Metrowest Phase 1 - North Somerset Council as Local Planning Authority response to Examiners Questions ExQ2

Reference	Question to:	Question:	North Somerset Council as Local Planning Authority Response
GC.2.2	<p>Updates on development</p> <p>All Relevant Planning Authorities</p>	<p>Provide an update of any planning applications that have been submitted, or consents that have been granted since the last set of written questions that could either effect the proposed route or that would be affected by the Proposed Development and whether this would affect the conclusions reached in Chapter 18 and Appendix 18 of the Environmental Statement (ES) [APP131 and APP-191]?</p>	<p>Application 19/P/2947/FUL At Royal Portbury Dock - Former BCA site Marsh Lane – erection of extension to existing building and erection of new building to be used for the preparation of cars prior to sale has now been approved.</p> <p>An application at 49 Martingale Way, Portishead (reference 21/P/0301/FUL) has just been submitted for: Change of use from Assisted Living Development comprising 126 apartments and integrated care, support and well-being facilities for the over 60's age group (Use Class C2) to 127 non-ag

Drawing **PILL TUNNEL EASTERN PORTAL COMPOUND LANDSCAPING & ACCESS PLAN SHEET 1 OF 2**

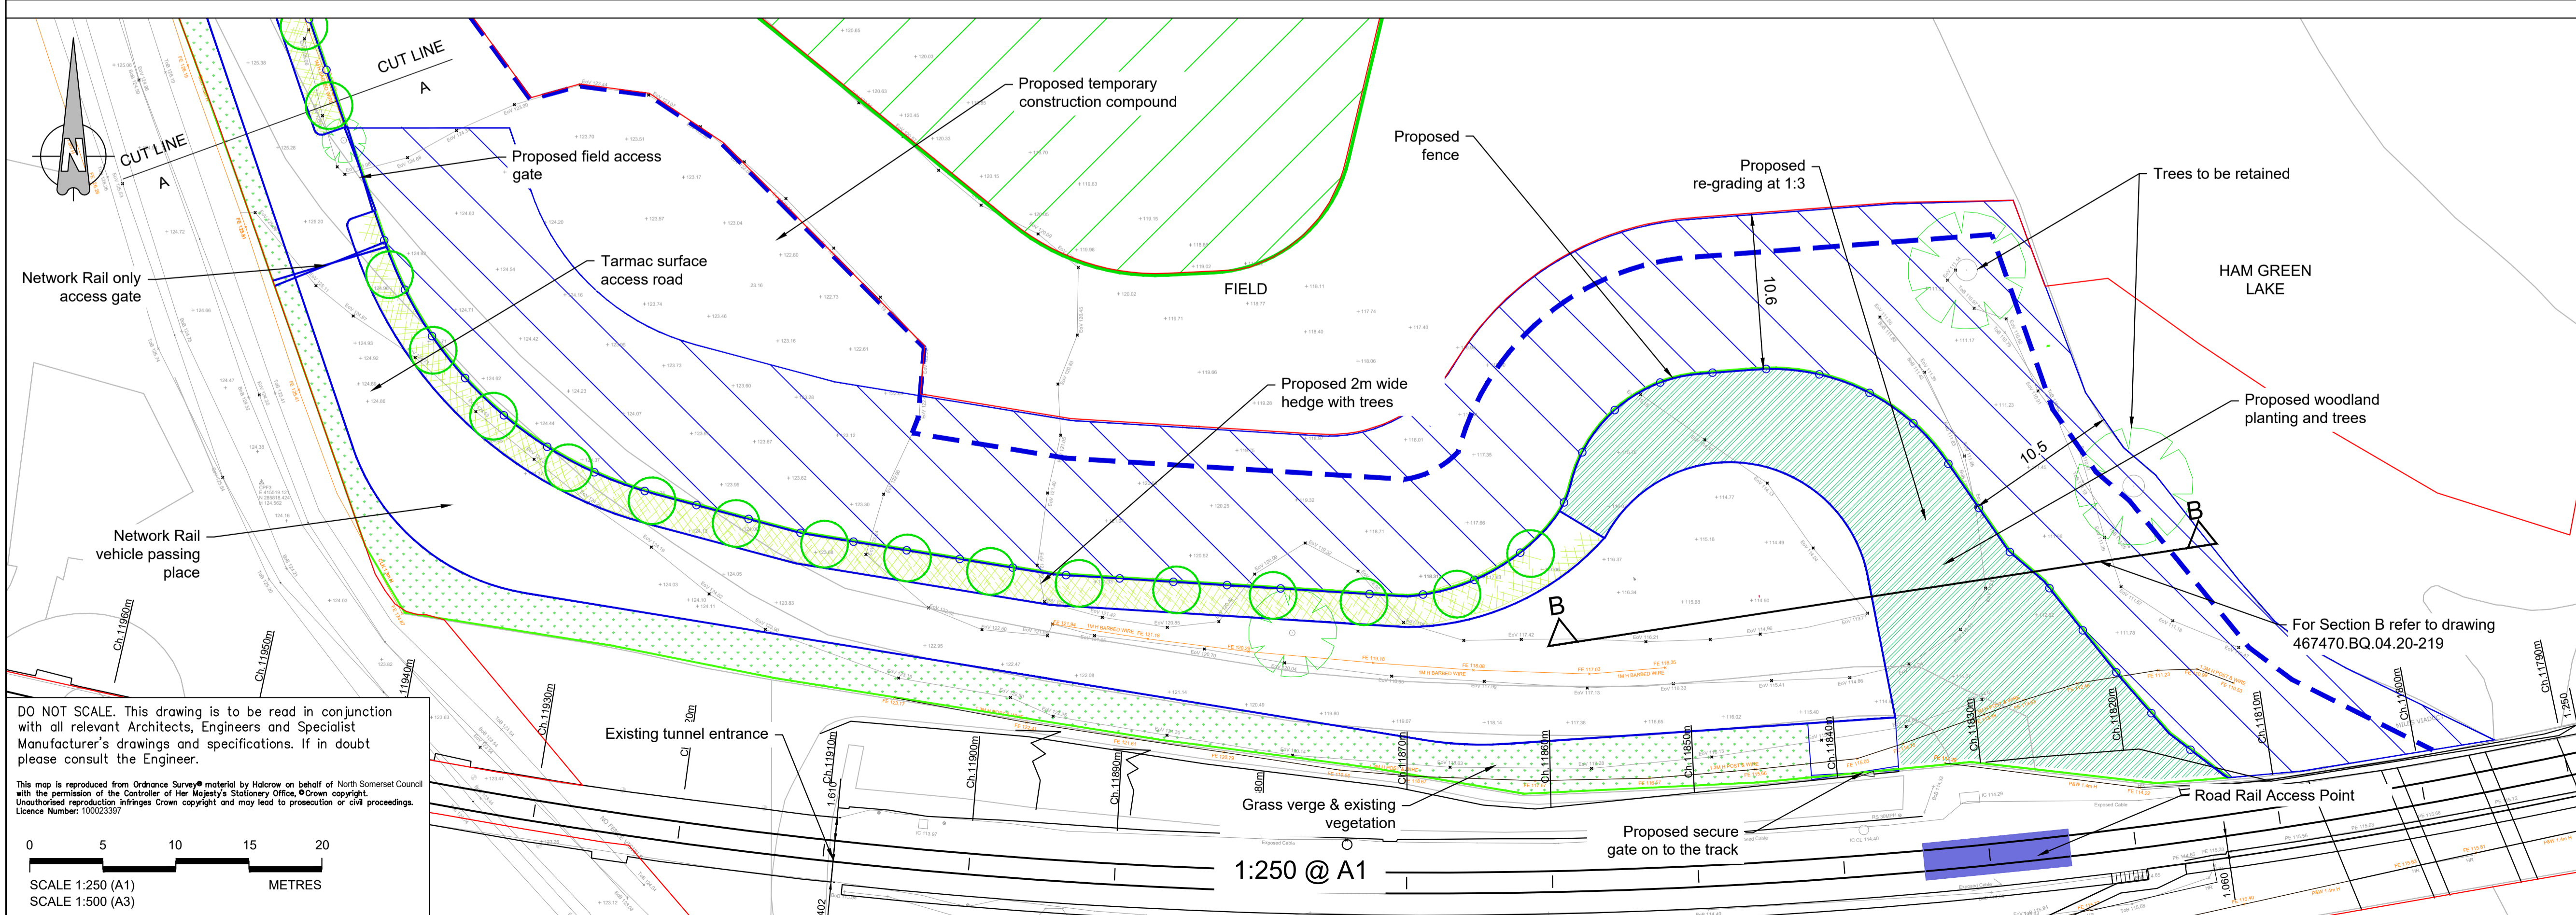
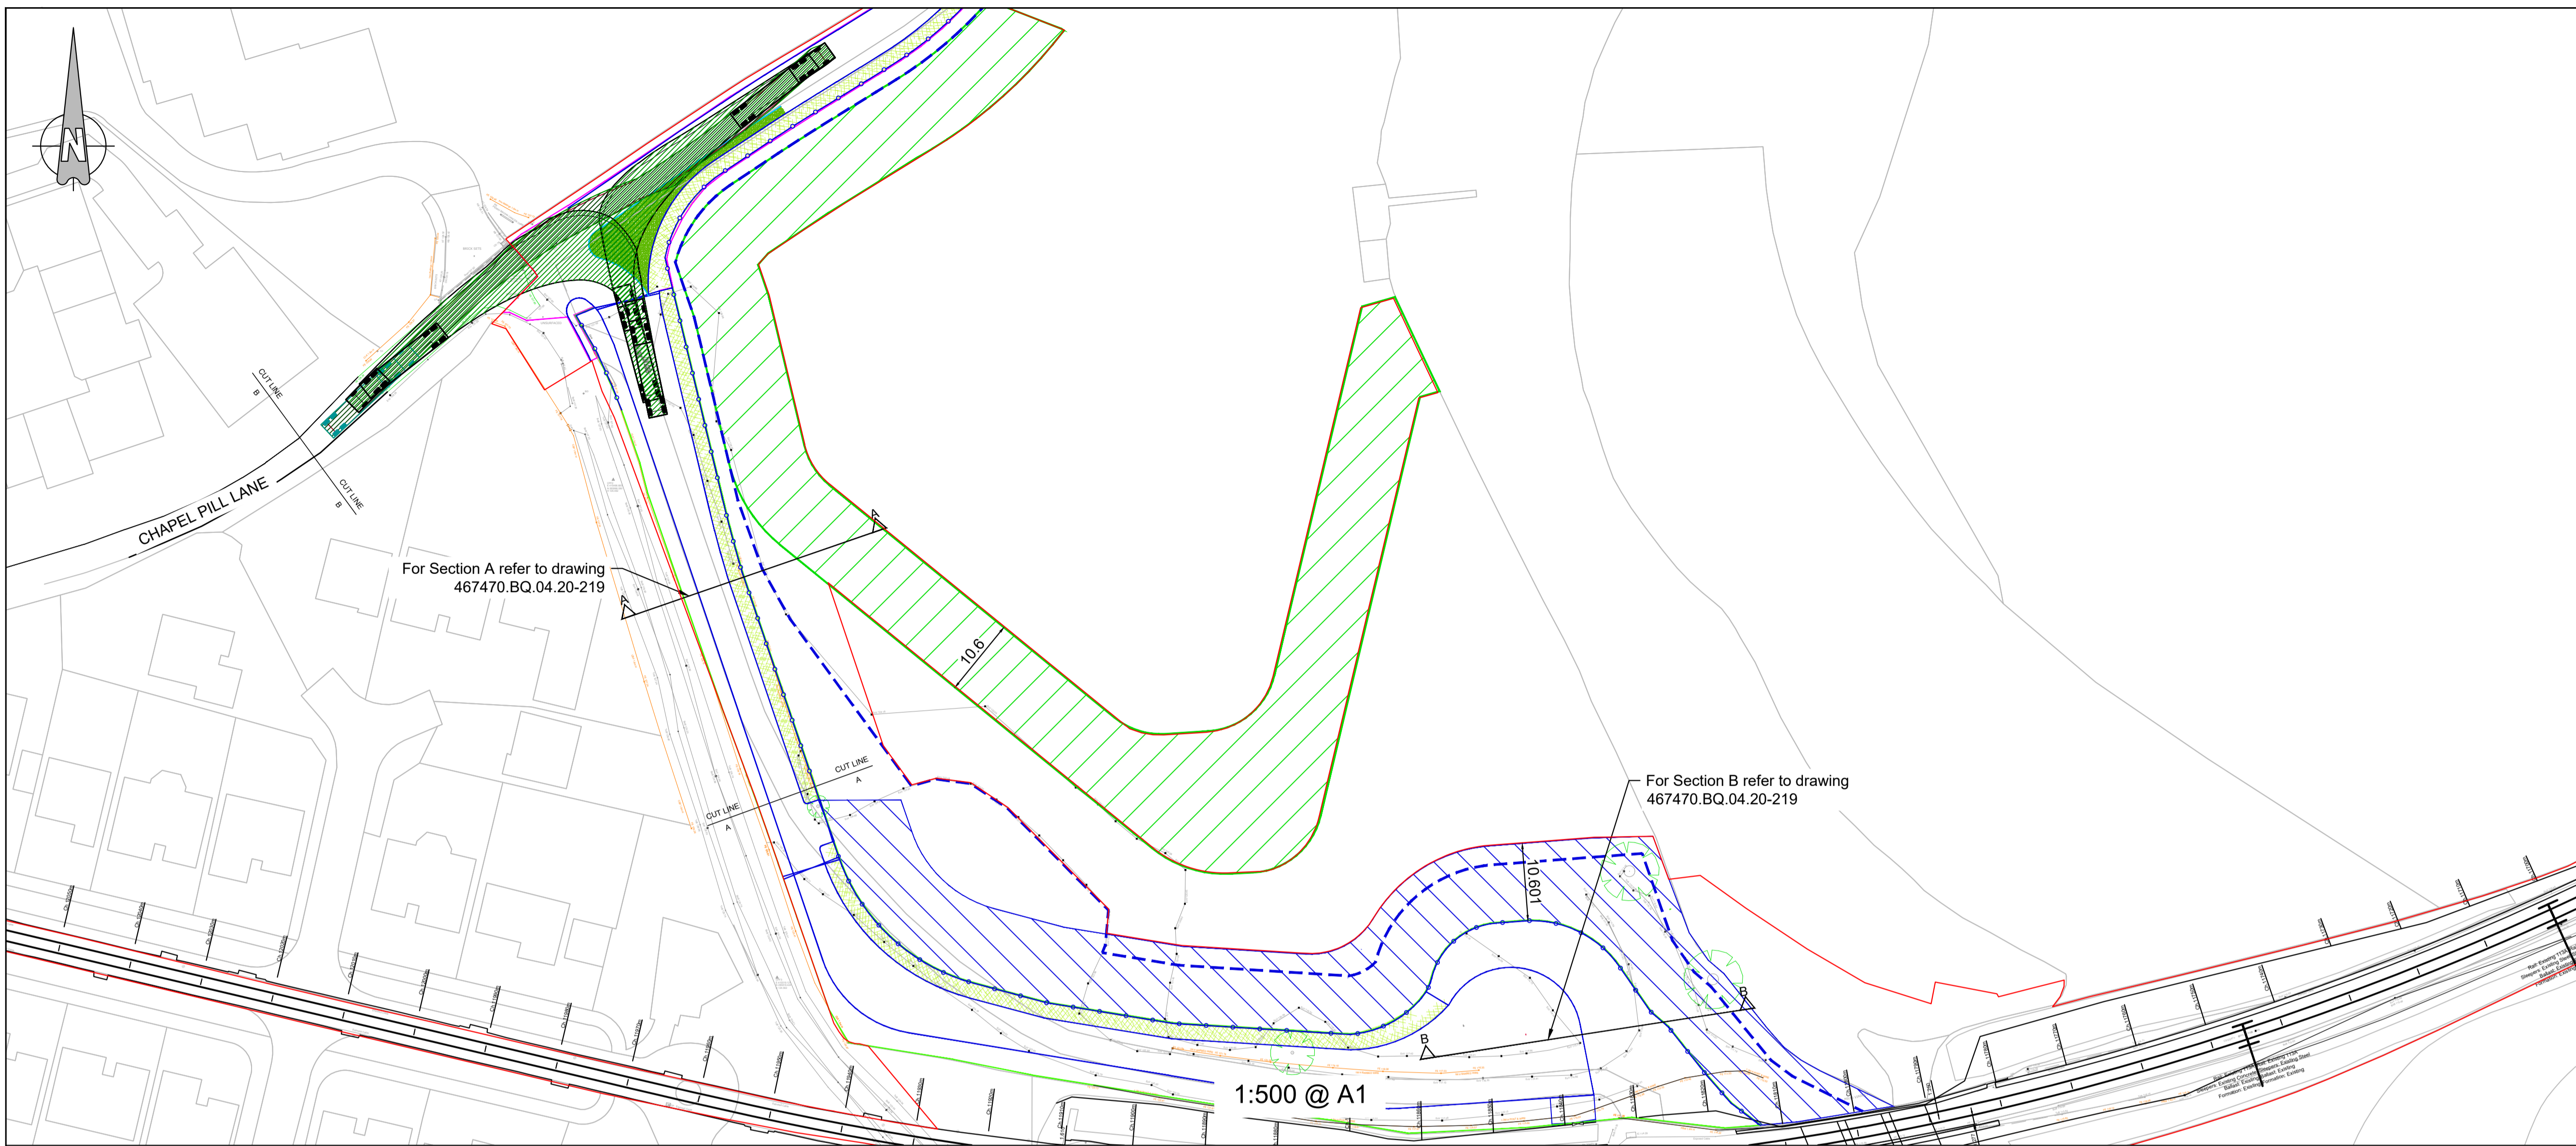
<p>in its Deadline 4 response [REP-064] and provide a sufficient mechanism to deliver any necessary measures in relation to the toads at Lodway Farm? If not, why not and what measures would you consider necessary?</p>	<p>management, water abstraction from water bodies and design of drainage features).</p>
<p>Cl.2.2</p>	<p>Access at Portbury Hundred</p> <p>The Applicant North Somerset District Council</p>	<p>Permanent access into Portbury Hundred following use of land as a temporary construction compound is required as an alternative farm access following closure of a crossing. However, the scale of the junction would be far bigger than what would be required for an agricultural access.</p> <p>The Applicant's response to ExQ1 at TT.1.3 [REP2-013] states that it is not the intention to alter the access in size or specification once the compound is no longer required for construction. The access is only required to enable access to the land at Elm Tree Farm after construction. Given its location in the Green Belt a large overengineered permanent access would appear to be unnecessary.</p> <p>Applicant: NB no i)</p> <p>ii)Provide an explanation as to why the access would not be reduced in scale given its Green Belt location.</p>	<p>We have reviewed the latest Plan TR40011 dated November 2019.</p> <p>Due to the high-speed nature of Portbury Hundred, we consider that the temporary access for the works compound will be appropriate for the permanent agricultural access. The latest plans clearly show that the gateway setback is 20m and no longer. Whilst we would normally require a minimum gateway setback of 12m on an agricultural access, the plans show tracking for a tractor and hay trailer of around 19m total length, so a 20m setback is appropriate for such a vehicle.</p> <p>The width of the access will allow a tractor and trailer to turn in off the highway whilst another is waiting to pull out of the access. This will mean that no part of the incoming vehicle is blocking the highway. Whilst there is no obvious need for the internal trackway beyond the gates to be 8m wide on an agricultural track, we have no highway view on this.</p>

<p>iii)How would its use by vehicles other than those associated with the farmland be prevented? NSDC: Do you consider the access should be altered to dissuade inappropriate future use following closure of the construction compound?</p>	
CA.2.1	<p>Royal Portbury Dock</p> <p>The Applicant North Somerset District Council</p>	<p>The BPC [REP4-060] has provided a detailed response regarding the number of train movements into and out of the port that it considers are allowed by the planning permissions granted in 2000 and 2011. At the ISH2 [EV-009] you appeared to indicate that you thought that the number of daily movements was limited to a total of 20 movements. Can you:</p> <p>x)Comment on the response provided by the BPC; and</p> <p>xi)Comment on the wording suggested by the BPC for a Protective Provision in relation to this matter.</p>	<p>x) The Port Company is correct about the 2011 permission allowing for 40 movements. The condition says the number of freight trains using the Rail Link, shall not exceed an average of 20 trains daily per calendar year in and out of the Portbury docks.</p> <p>xi) No comments on the wording suggested by BPC for a Protective Provision.</p>
